Ref: Mr and Mrs Collins, 6 Angelica Close, Swindon, SN2 2TS Query on Application
S/HOU/20/1638/EMMI

We have today received a notification that our neighbours at No. 5 Angelica Close, Woodhall Park, Swindon SN2 2TS have applied for planning permission for erection of single storey side extensions.

PROPOSED - PLAN

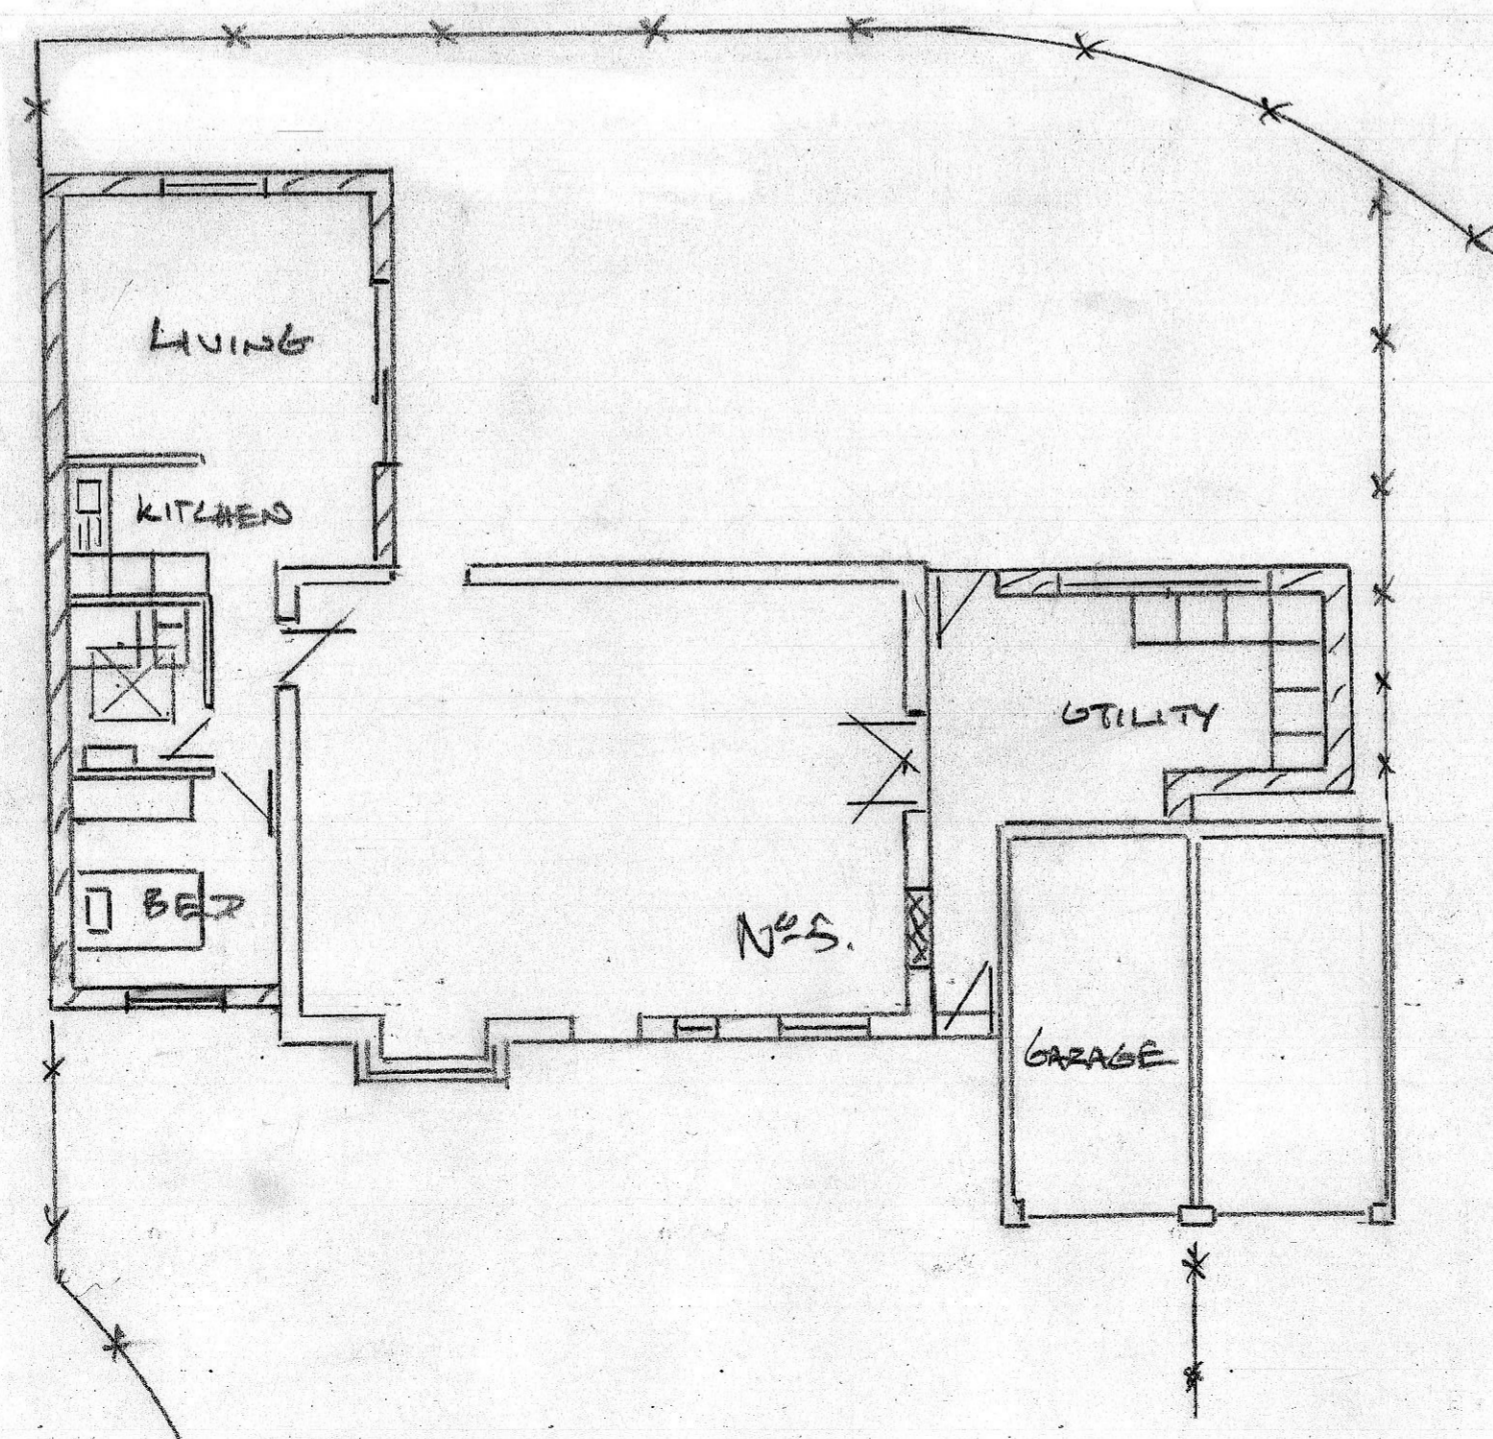
We see from the said proposal, that a gap is being left at the back of our garage for maintenance purposes but this appears to be minimal, the plan does not state the dimensions of what area this will give for us to maintain our own property.

Secondly, we then have the issue of access to said garage for maintenance, as this would now be through our neighbours new extension. This causes issues on both fronts as far as we can see from the plans received. We would like clarification on dimensions and access to our property which is now affected by this proposal.
